From: Laura Gibbons <Laura.Gibbons@arun.gov.uk>
Sent: 21 December 2021 16:04
To: Planning.Responses <Planning.Responses@arun.gov.uk>
Cc: Kathryn Welch <Kathryn.Welch@arun.gov.uk>
Subject: FW: Planning Consultation on: WA/119/21/DOC

Engineers Comments Regarding Condition 6

Site Address: Willows West Walberton Lane Walberton BN18 0QS

Description of Works: Approval of details reserved by condition imposed under WA/28/21/HH relating to condition 6-surface water drainage.

Drawn by: KS	Title: The Willows Surface water attenuation scheme
Checked:	
Date: Sept 2021	Drawing No: SCEL-2099-01
Scale: See bar

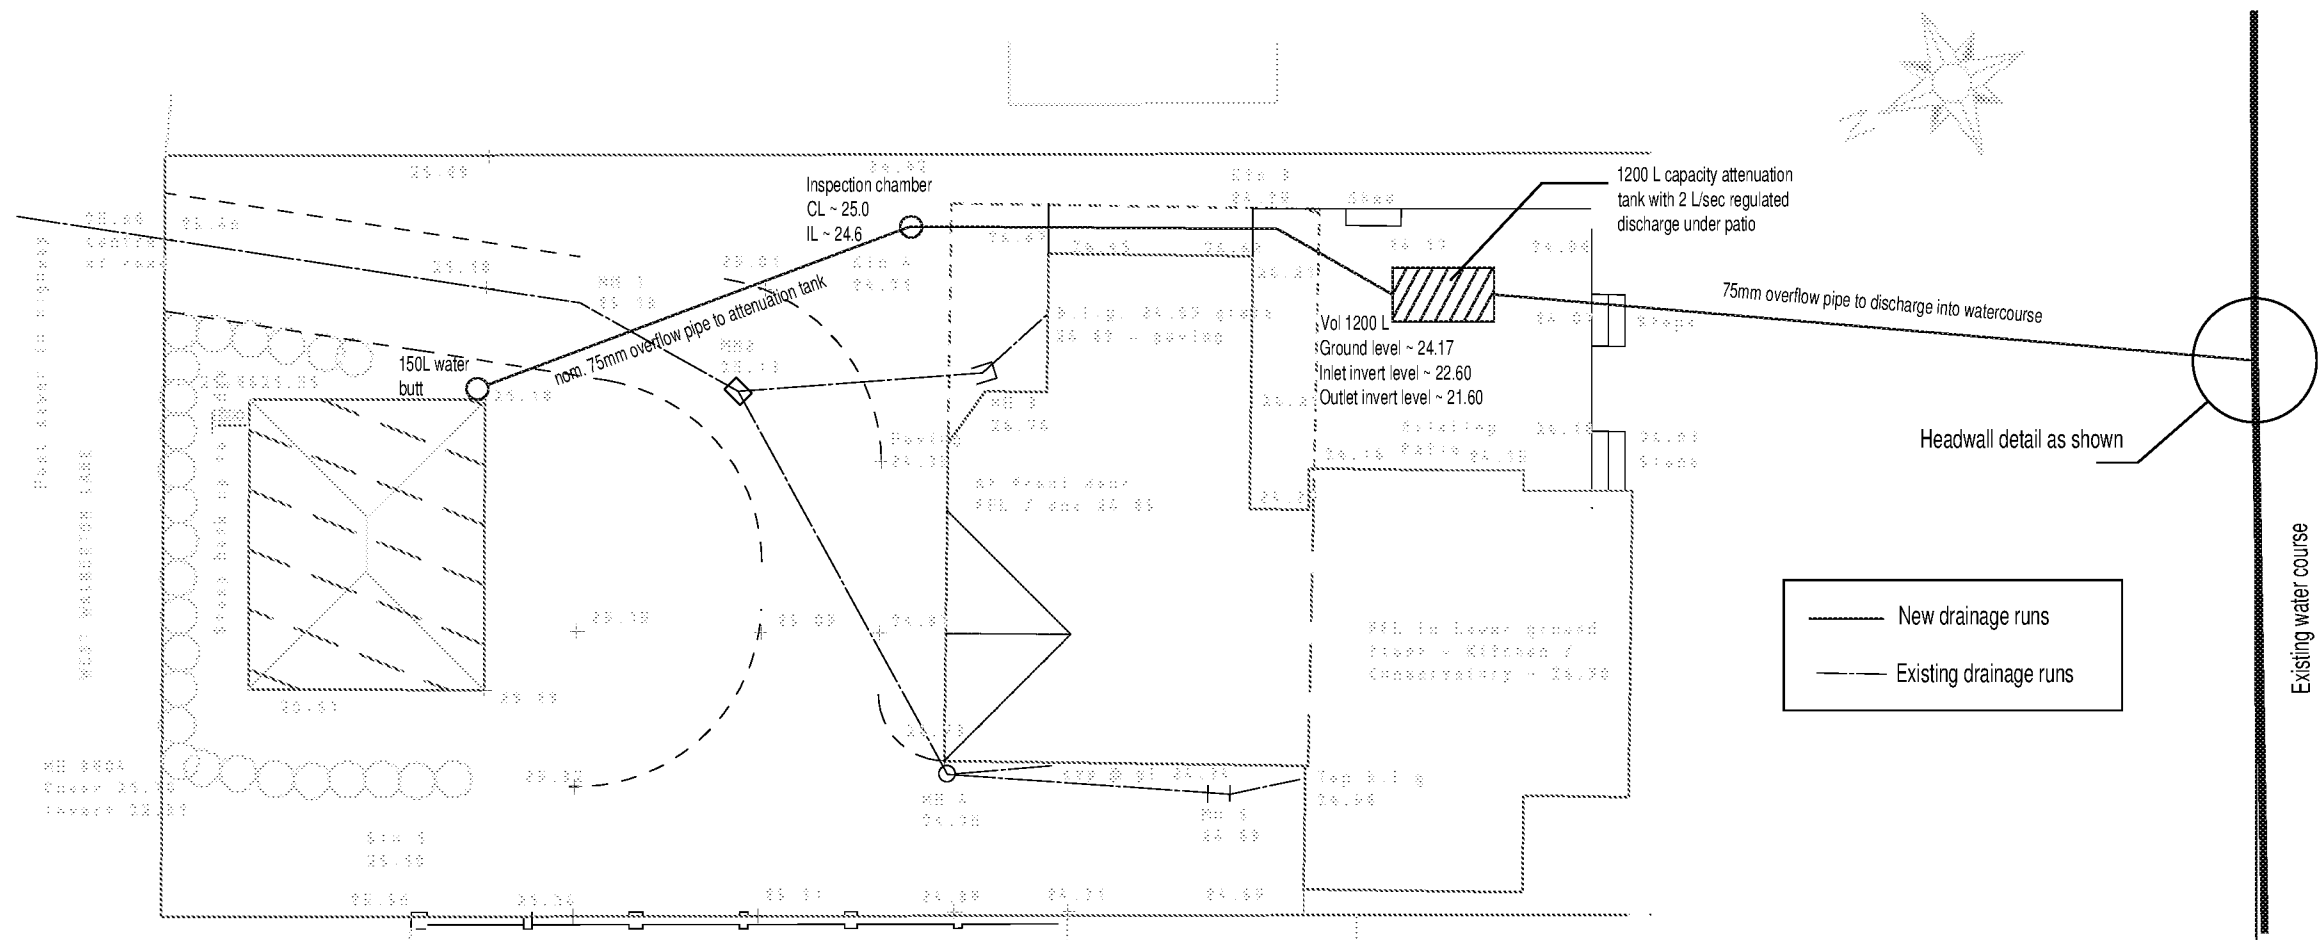
1. Please supply winter groundwater monitoring results.
2. Please supply construction detail drawings of; pipe bed and surround, catchpits, attenuation tanks, flow restriction device, and headwall.
3. Please provide bed levels of the watercourse.
4. Please label layout with invert level of proposed outfall to watercourse.
5. Please label all pipes with diameter and fall.
6. Please provide a catchpit upstream of the attenuation tank.
7. Please label invert and cover level of tank. Please also state required attenuation tank dimensions. Flotation calculations may be required to support design.
8. Please supply evidence of consent for the proposed outfall.

9. Please confirm if a separate outfall is proposed for WA/118/21/DOC
